WEST SUSSEX COUNTY COUNCIL CONSULTATION

TO:	Arun District Council FAO: Anita Gardner
FROM:	WSCC - Highways Authority
DATE:	6 April 2021
LOCATION:	Land between 11a The Grove and 30 Brook Lane Ferring
SUBJECT:	FG/46/21/PL Development of 1 no. 2 bed house set over 2 floors, with first floor being partially contained within roof, along with associated parking & amenity spaces. This site is within CIL Zone 4 and is CIL liable as new dwelling.
DATE OF SITE VISIT:	n/a
RECOMMENDATION:	Advice
S106 CONTRIBUTION TOTAL:	n/a

Drawing Title 028_02 Proposed Ground Floor Plan Land between 11A The Grove and 30 Brook Lane, Ferring					
Completion date 17/03/2021					
Drawn by Guy Rochez ARB					
Scale: 1:100@A3					
Print Size: A3					
Notes:

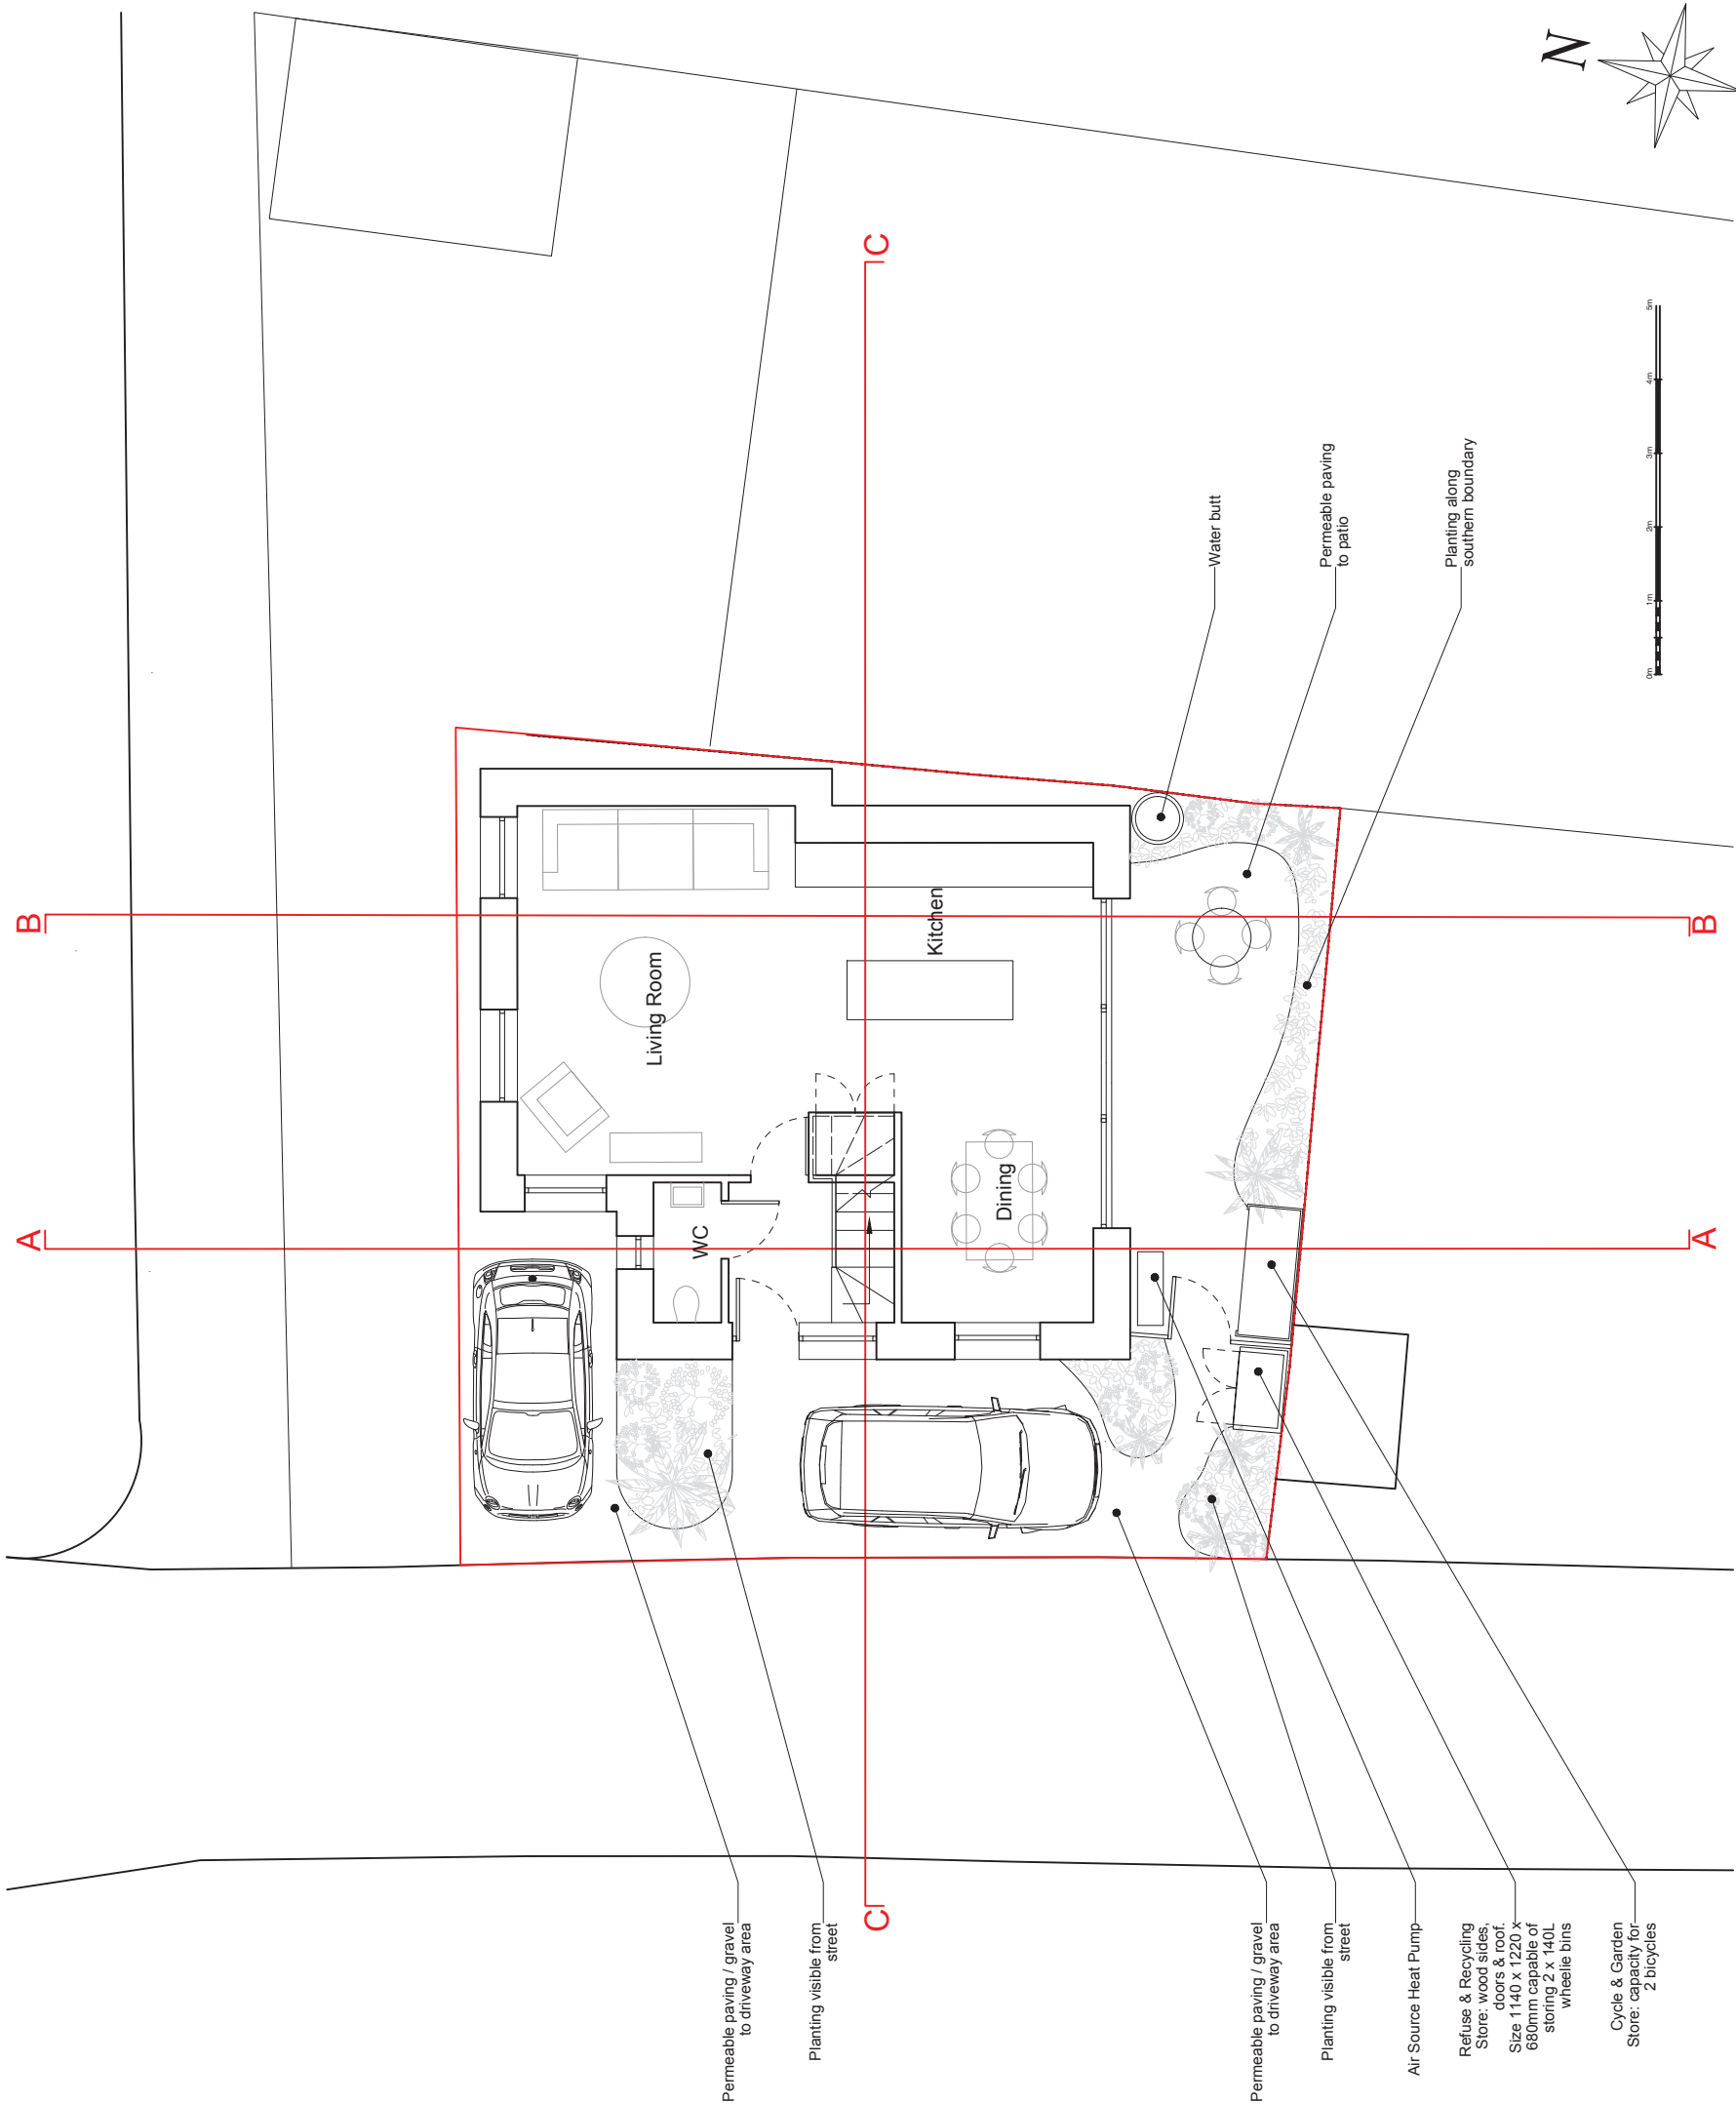
The plans demonstrate two parking spaces for the proposed dwelling, which is anticipated to be sufficient for a dwelling of this size and location. Each space should meet minimum specifications of 2.4 x 4.8m as set out in Manual for Streets. It appears that one of these spaces does not meet this minimum specification, however the LHA acknowledges that a small vehicle could utilise this space. The LPA may wish to consider the amenity impacts of the proposed smaller space and whether this would impact upon on-street parking in this location.
